EN010085 - Application by Cleve Hill Solar Park Ltd for an Order Granting Development Consent for the Cleve Hill Solar Park

RE: Advice Following the Issue of Decision to Accept the Application for Examination

Table 1 - Applicant's Response to Inspectorate's Observations

Crown Plan in accordance with Regulation 5(2)(n) of The Infrastructure Planning (Applications: Prescribed Forms and Procedure) Regulations 2009
Sheet 2 of 3

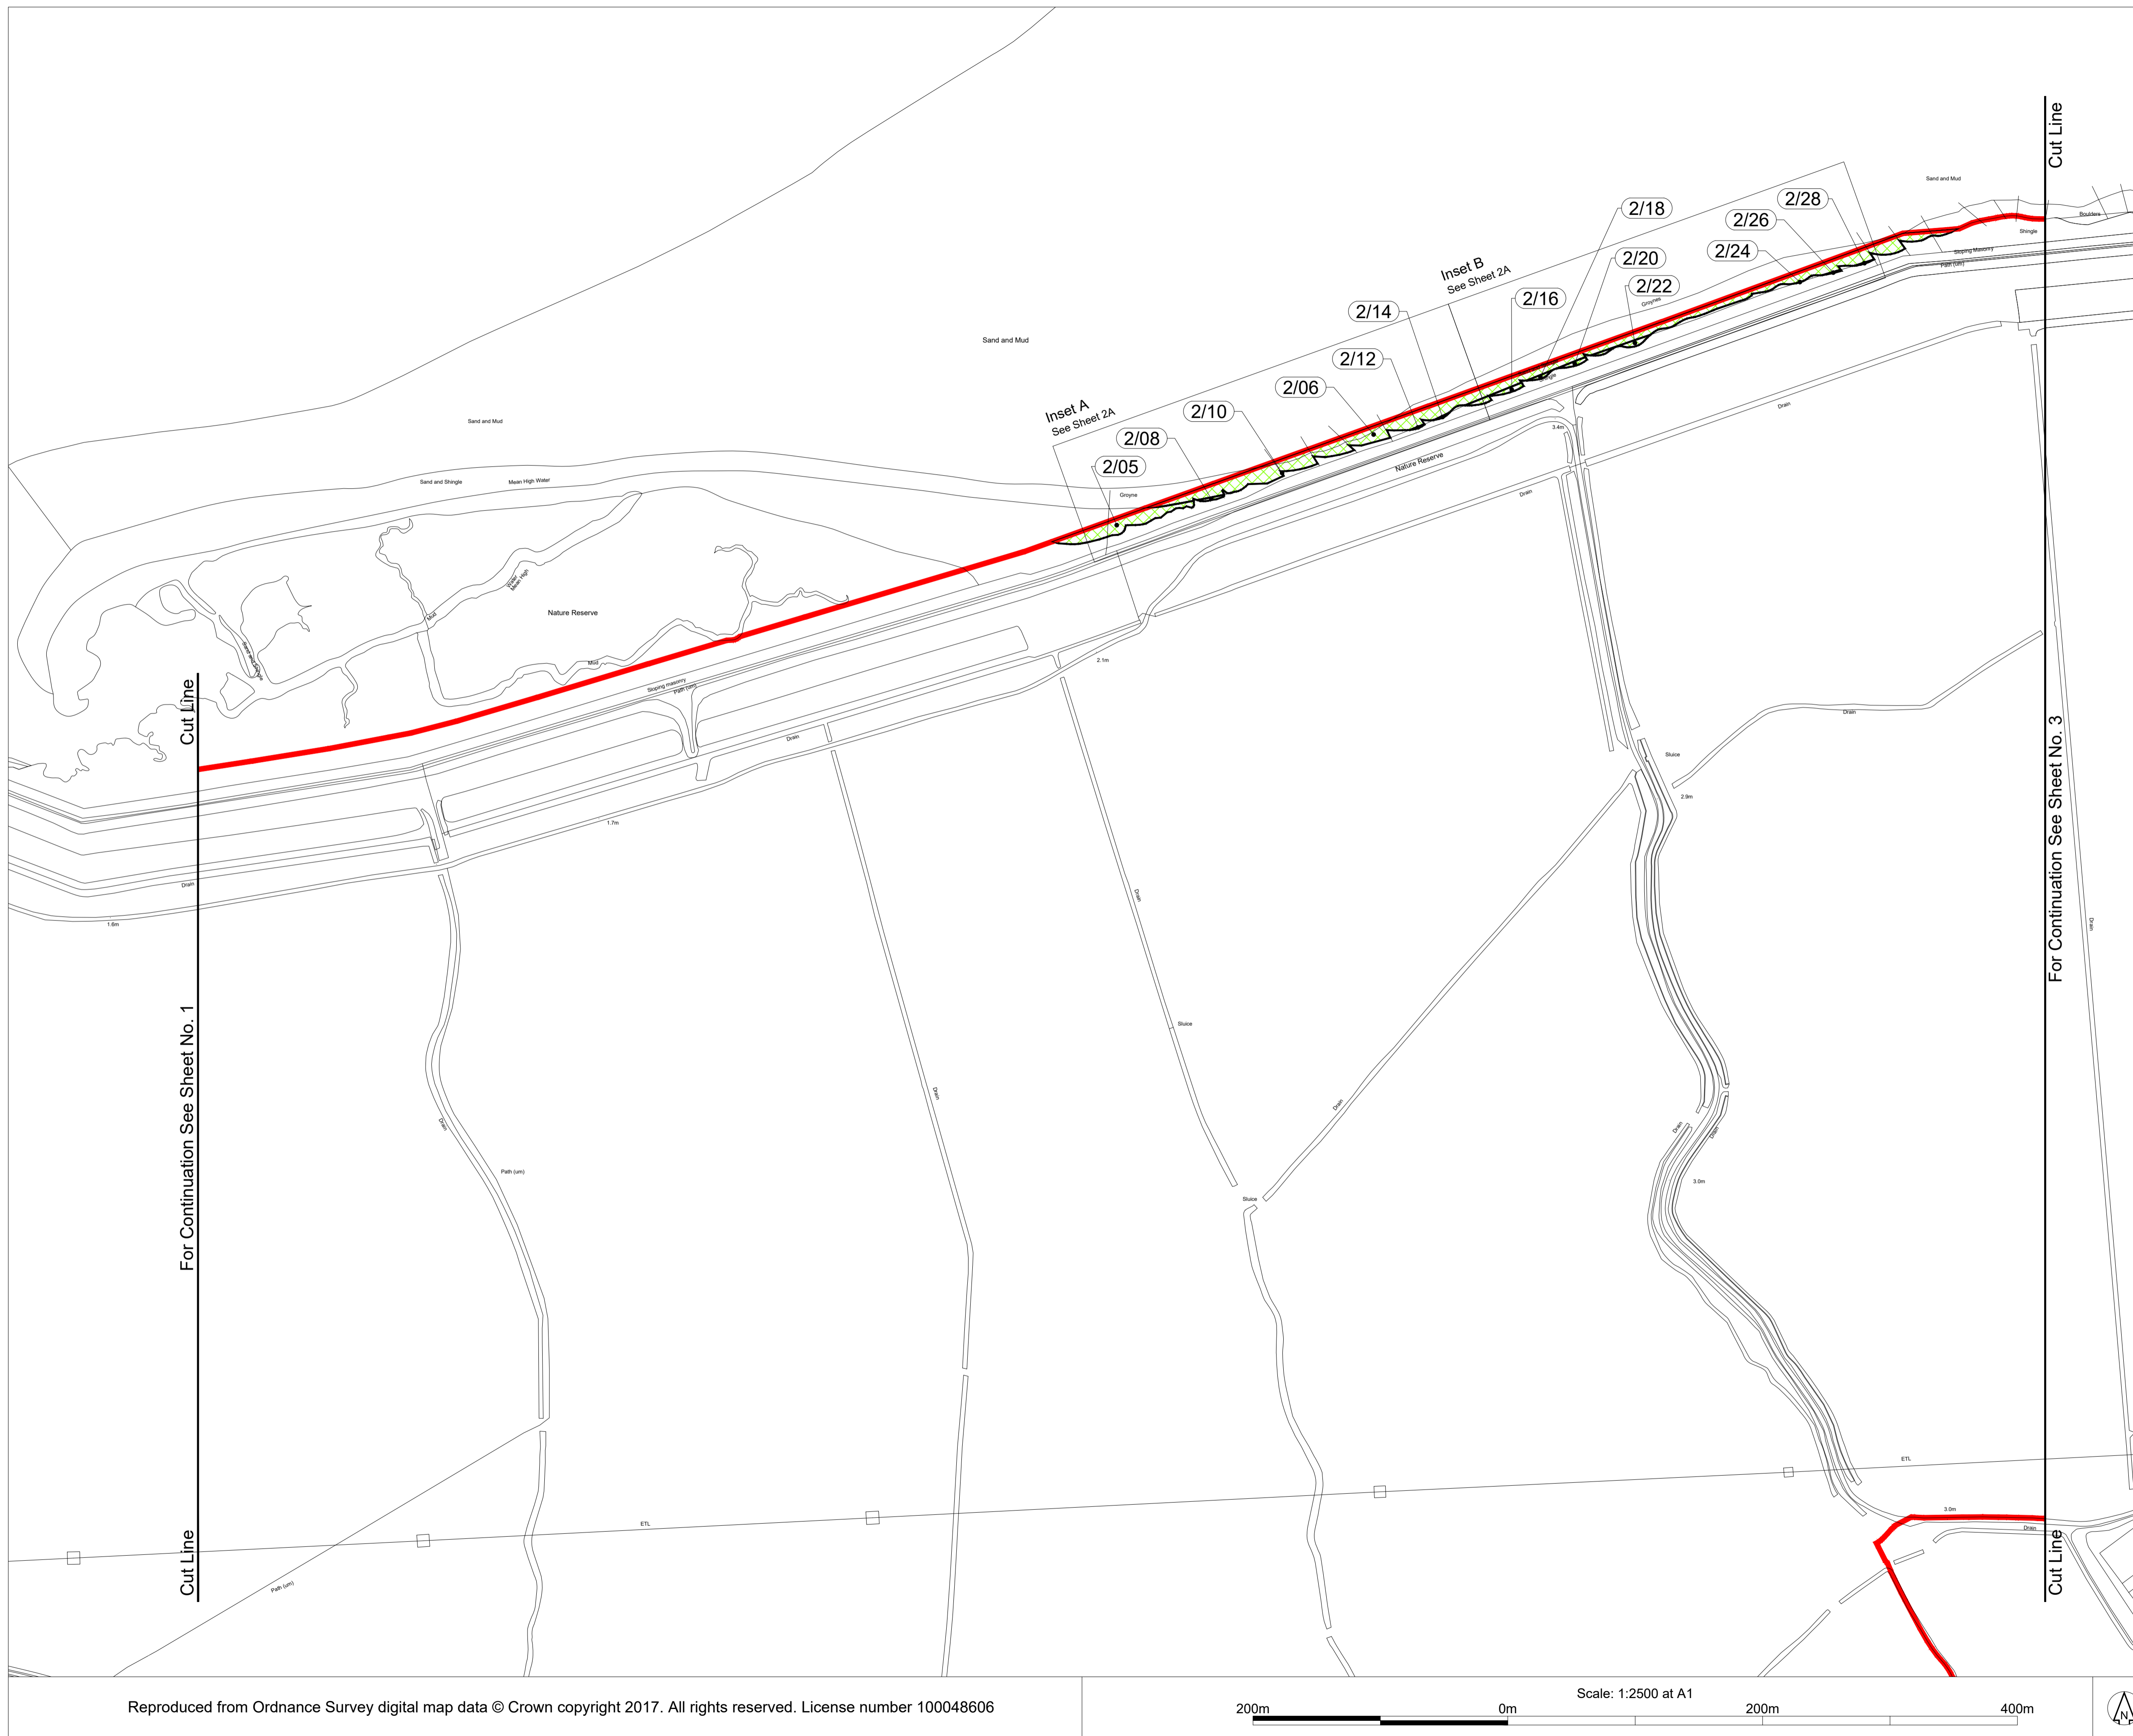
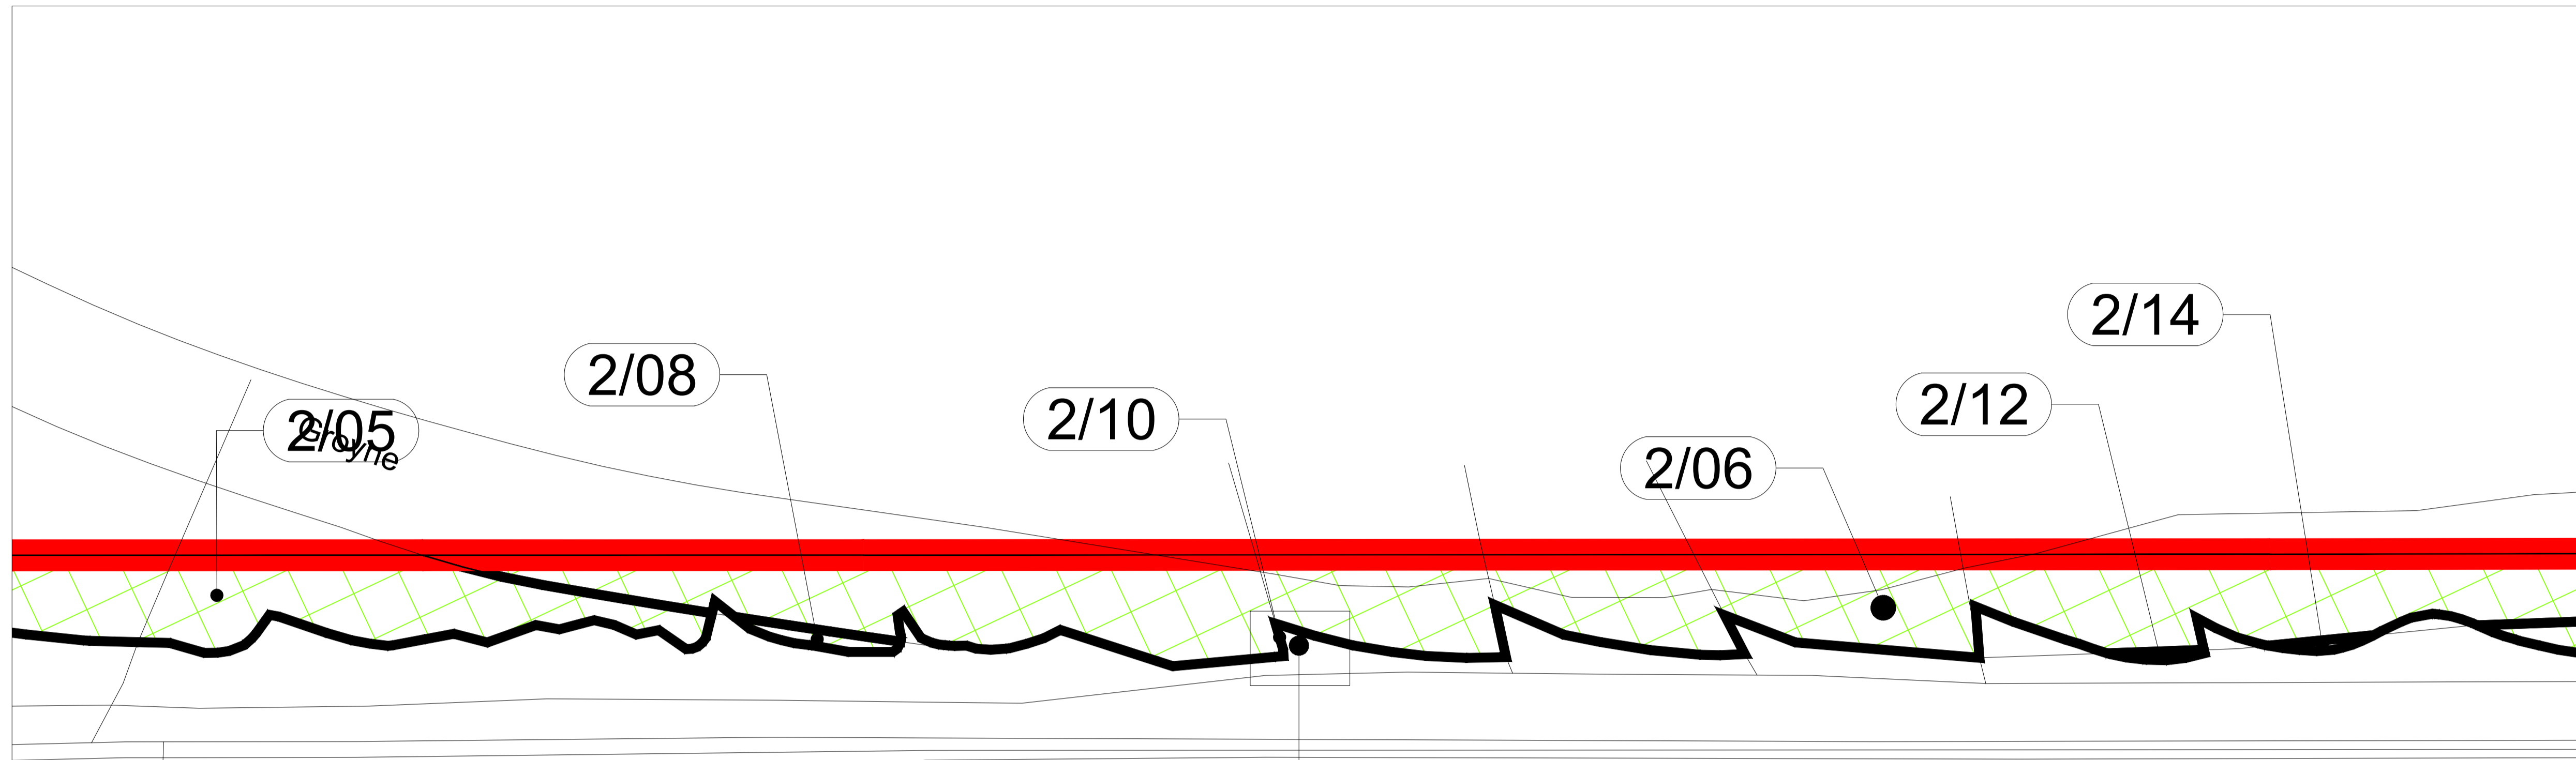
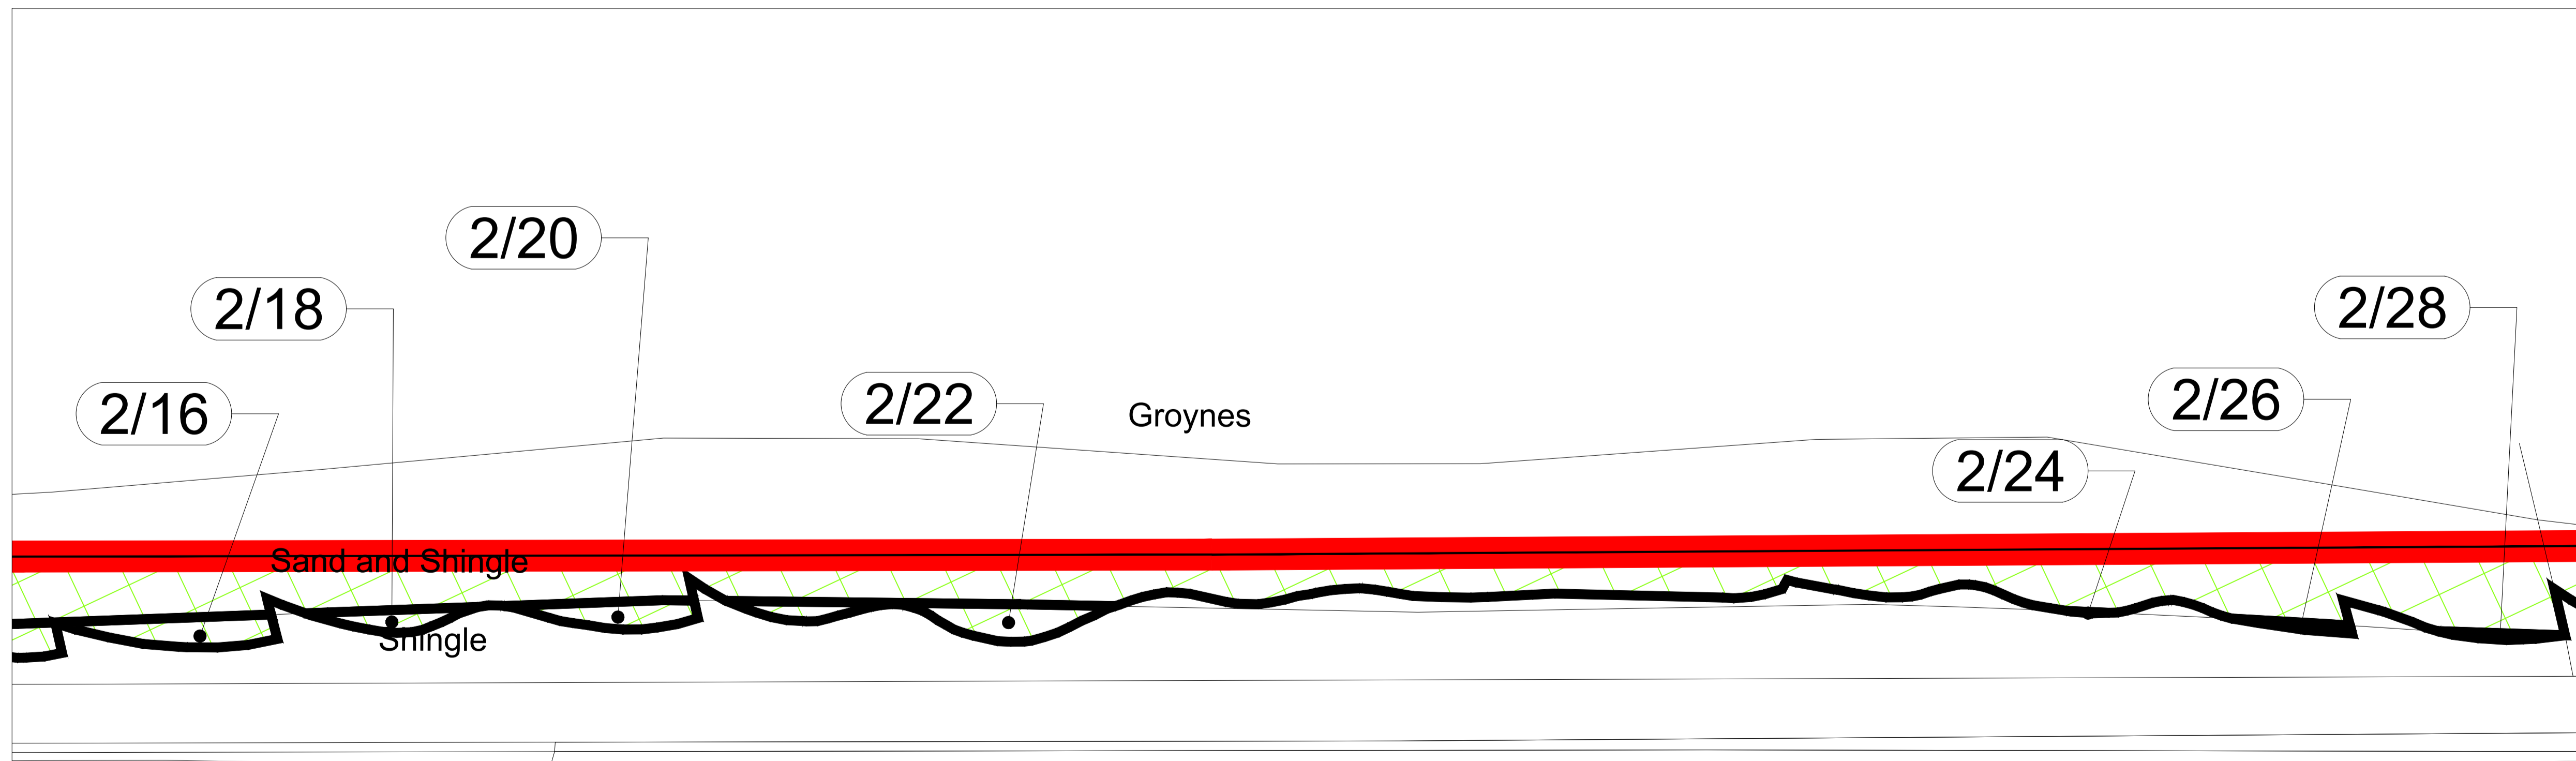
Distinction between start and end of given paths is unclear. Figure 3 shows paths ZR692 & CW90 as one complete footpath but there is no point at which one becomes the other (same for ZR484 & CW55).	The enclosed Rights of Way Plan has been updated to clearly show the start and end of given paths (doc 2.3, Revision B).
'Proposed Permissible Footpath' (as shown on Figure 3 of the Rights of Way plans (Doc Ref 2.3) does not appear to be cited in the dDCO.	This relates to the permissive path that is included in the authorised development. It is proposed that the public will have permissive access to the path, but it will not be designated as a PRoW/footpath. For that reason the permissive path is only included in Schedule 1 of the draft DCO under further associated development (f) " <i>permissive paths</i> ".
Crown Land Plans	
The Inspectorate has noted that the inset sections detailing the smaller plots (used on the land plans (Doc Ref 2.1)) are missing from the Crown Land plans. This can make seeing the affected plot difficult without also viewing the land plans. Please can the Applicant provide clarity on this.	Inserts have been added to the enclosed Crown Land Plan (Revision B).
